**Consultation Response from KC,
Highways Development Management****2024/92168 Land south of, Leak Hall Barn, off Leak Hall Lane, Denby Dale, Huddersfield, HD8 8QU****Outline application for erection of residential development of 13 dwellings****Date Responded: 24/01/2025****Responding Officer: Ryan Kinder****Responding Ref: K17-12-24**

2024/92168 Land south of, Leak Hall Barn, off Leak Hall Lane, Denby Dale

RECOMMENDATION: Further information requested as detailed in the comments below:

DRAWING TITLE
VEHICLE TRACKING AND VISIBILITY

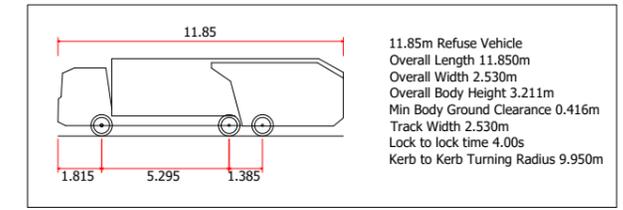
Visibility splays have been demonstrated of 2.4m x 25 to the right out of the development and to left which is within the RLB of the site – not specified. Given the achievable visibility indicated it is important that driven speeds are established on the approach from Leak Hall Lane, this should be undertaken via a 7 day automatic speed survey to give robust information on vehicle speeds.

With regards to visibility to the left an indicative dimension of the achievable visibility should be provided, it is acknowledged that this is a private drive with minimal traffic so the requirements in terms of distance can be relaxed somewhat. It should be noted however that this needs to be maintained in perpetuity, via adoption or maintenance agreement so clarification is sought on this matter.

Refuse storage and collection arrangements should be demonstrated and be in accordance with Local Plan Policy LP24 part d(vi). Swept paths for an 11.85m refuse collection vehicle are required and should take into account any on street parking and two way vehicle movements in particular on junctions, any tight bends and taking into consideration for parked cars on street..
